Grading and Erosion Control Plan_V1 REDLINES.pdf Markup Summary

DRAWN BY: O.E. WATTS		APPROVED BY:		REVISIONS 8-16-21 UPDATED		DEW		OLIVER E. WATTS		PROJECT		SHT. NO.	
DATE: 12-30-21		PROJ. NO. 19-5341-03		12-30-21 REVISED PER COUNTY REVIEW COMMENTS		DEW		CONSULTING ENGINEER		ROCKY TOP MOTEL & CAMPGROUND		1	
DWG. NO. 19-5341-03		DWG.						COLORADO SPRINGS		PART NW1/4 SECTION 9, T.13S., R.68W., 6TH P.M.		OF	
TOPOGRAPHY BY: CITY FMS 6-12-19										EL PASO COUNTY		3	
SURVEY INFORMATION BY: RAMPART JOB NO. 18384										GRADING AND EROSION CONTROL PLAN

PROJECT	SHT. NAME	SHT. NO.
	EROSION CONTROL DETAILS	OF

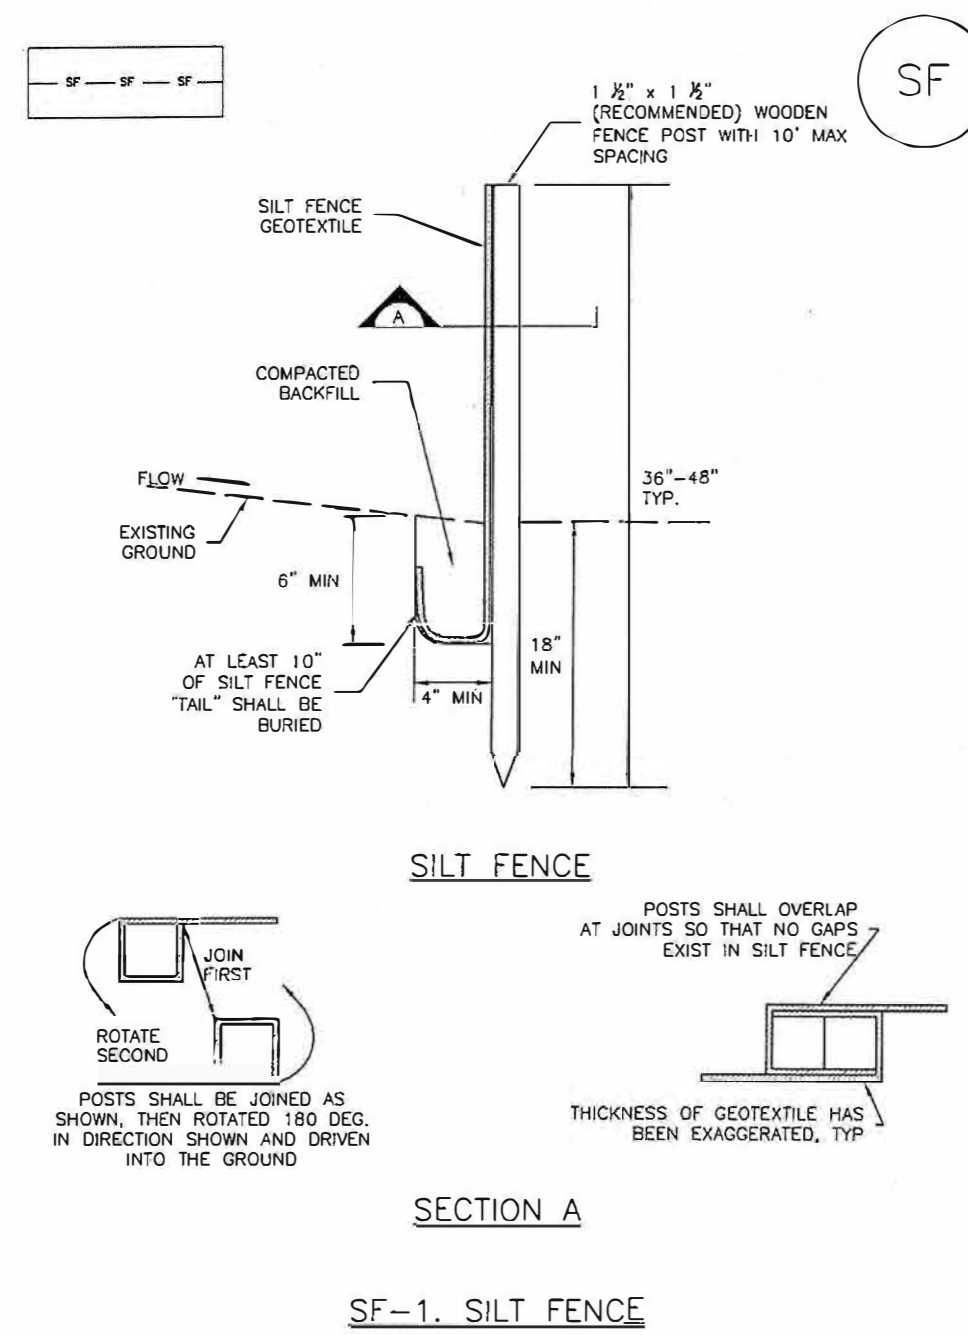
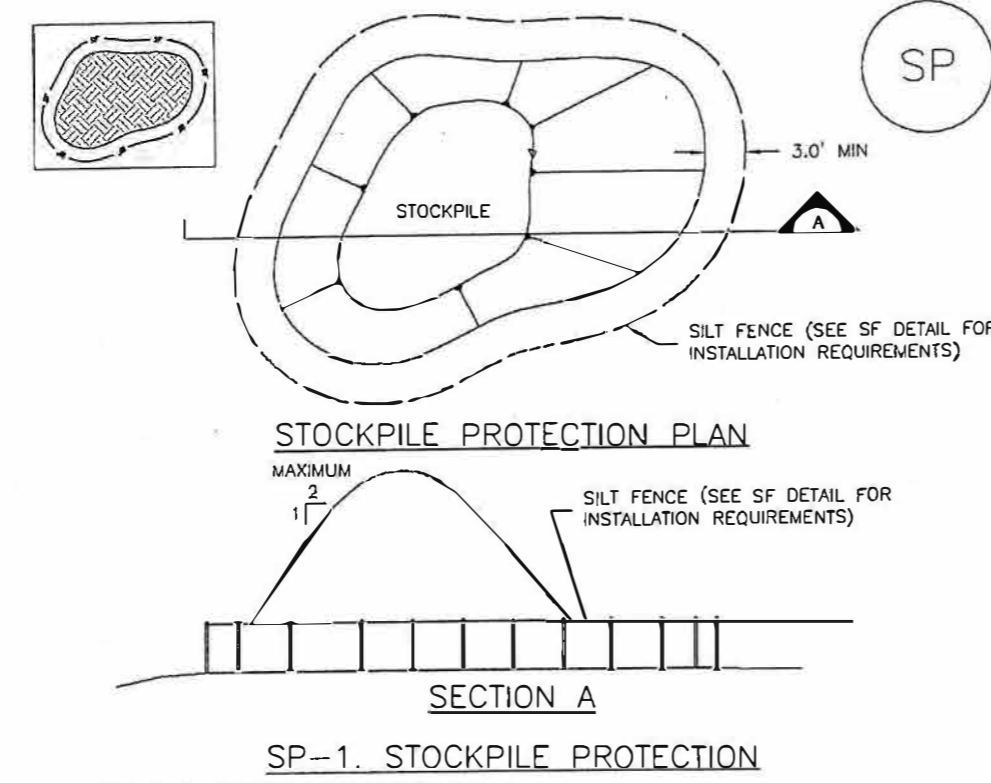
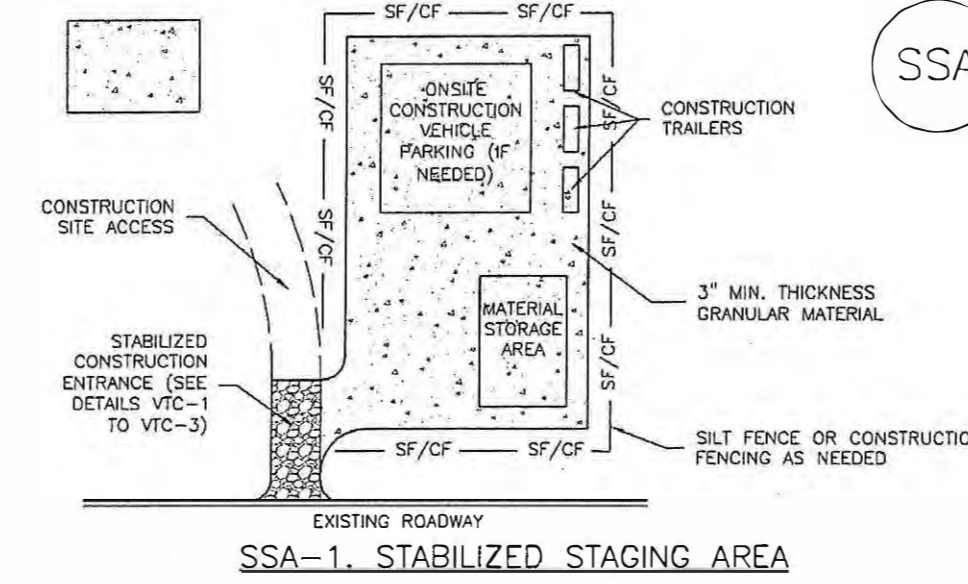
Revise to "Sand Filter Details"

Table not provided. Specify the filter material.

This is a generic detail that does not provide site-specific details. Like details about the orifice plate, location of spillway on the plans, outlet structure details, inclusion or exclusion of the option flood control volume, etc. As issued, the contractor will not know what to build.

Show the depth of the pond on a detail. This generic detail T-6 is not site-specific and does not show any dimensions for the actual sand filters.

provide a site-specific section that shows just the single underdrain instead of two.
